From: Claire Booth
Sent: 03 May 2012 15:05
To: Jane Tucker
Subject: FW: Consultation on planning application 3/2012/0259 Seven Acre Cottage, Forty Acre Lane, Longridge - Highway reponse

From: Hornby, Mark [mailto:Mark.Hornby@lancashire.gov.uk]
Sent: 03 May 2012 14:52
To: Claire Booth
Cc: ENV EPP Customer Service Area East
Subject: FW: Consultation on planning application 3/2012/0259 Seven Acre Cottage, Forty Acre Lane, Longridge

site plan. scale: 1:500

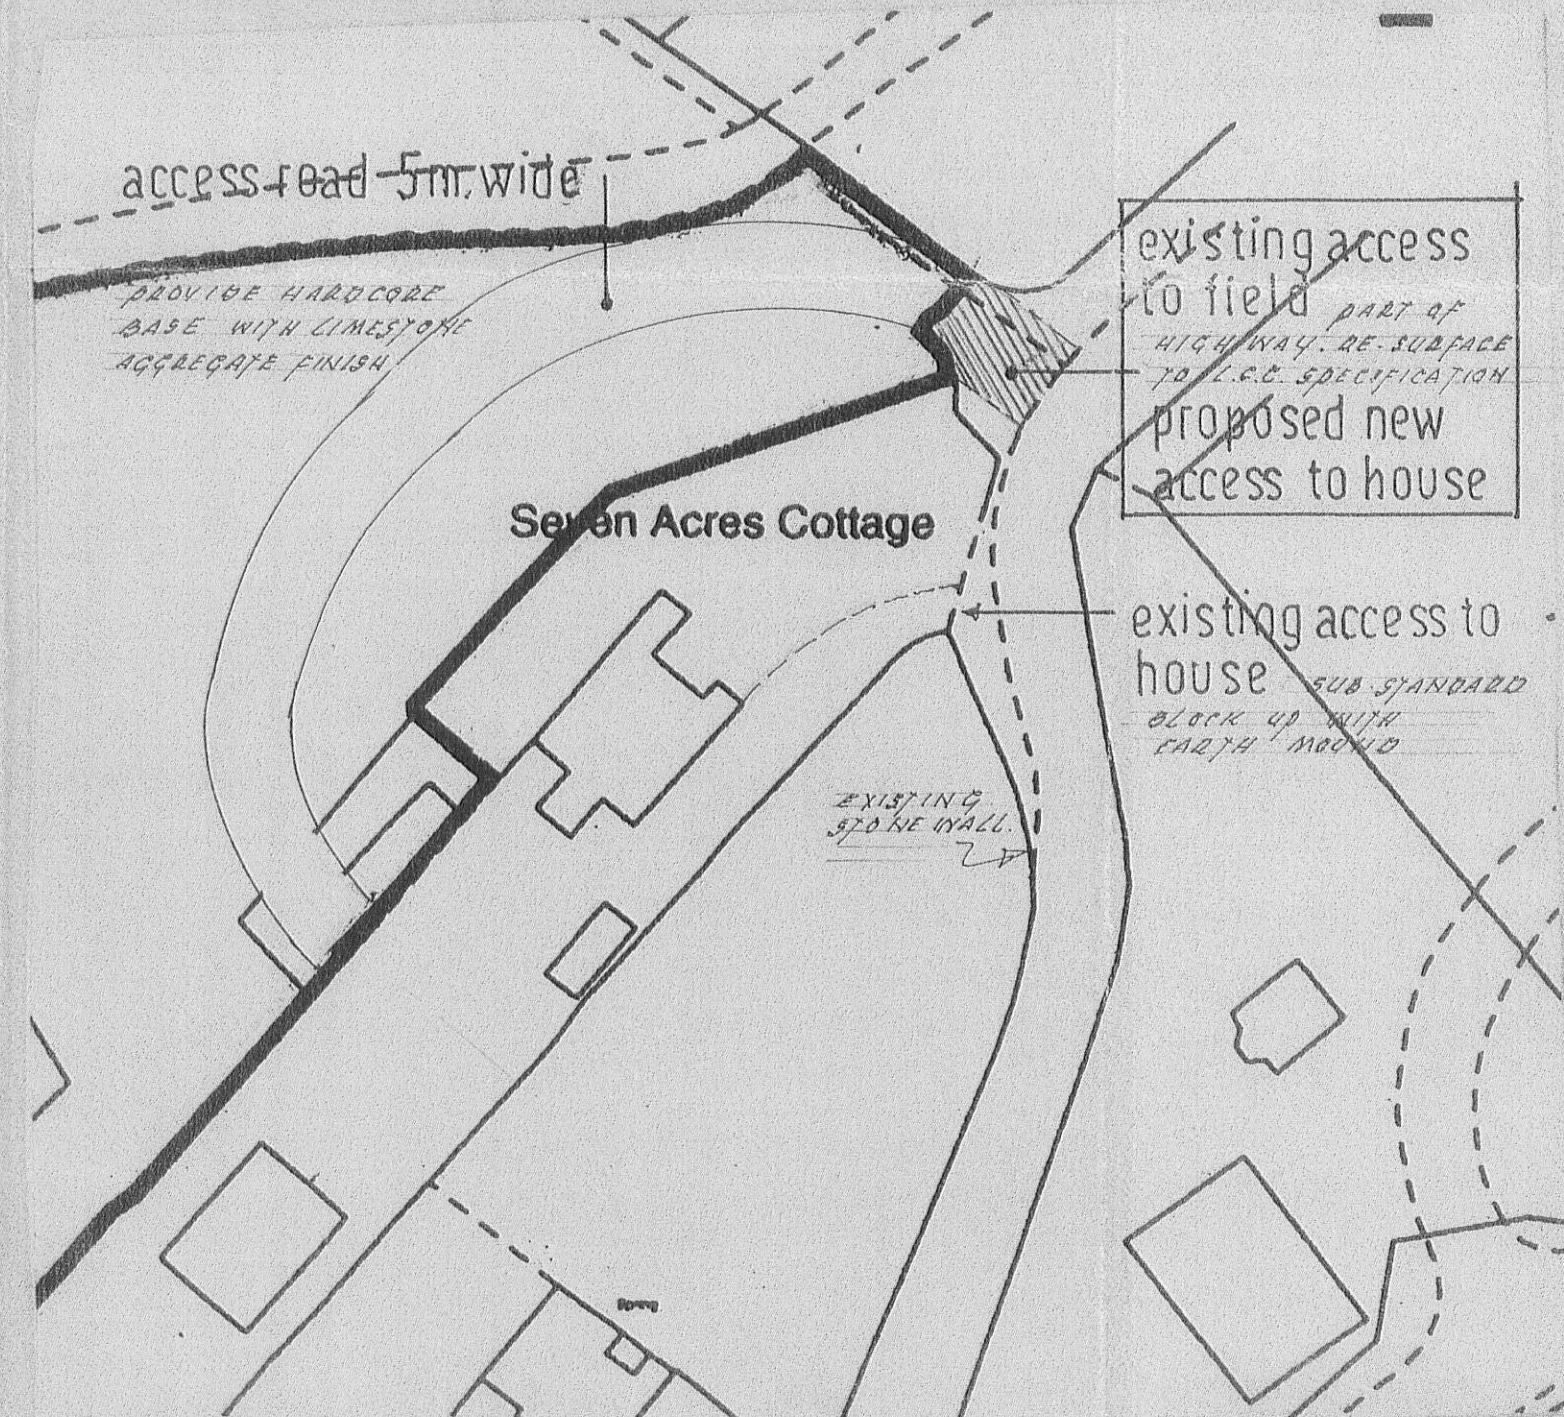
The available sight lines at the proposed new access are a significant improvement on the existing access and therefore I have no objection to this proposal subject to the following conditions:

1. Before the proposed access is used for vehicular purposes, any gateposts erected at the access shall be positioned 5 metres behind the nearside edge of the carriageway of Forty Acre Lane. The gates shall open away from the highway. Reason: To permit vehicles to pull clear of the carriageway when entering the site.

2. Before the access is used for vehicular purposes, that part of the access extending from the highway boundary for a minimum distance of 5 metres into the site shall be appropriately paved in tarmacadam, concrete, block pavements, or other approved materials. Reason: To prevent loose surface material from being carried onto the public highway thus causing a potential source of danger to other road users.

3. The proposed access driveway shall be constructed to a minimum width of 5 metres and this width shall be maintained for a minimum distance of 5 metres measured back from the nearside edge of the carriageway of Forty Acre Lane. Reason: To enable vehicles to enter and leave the premises in a safe manner without causing a hazard to other road users.

4. The existing access shall be physically and permanently closed and the verge shall be reinstated. Reason: To limit the number of access points to the highway at this location in the interests of road safety.
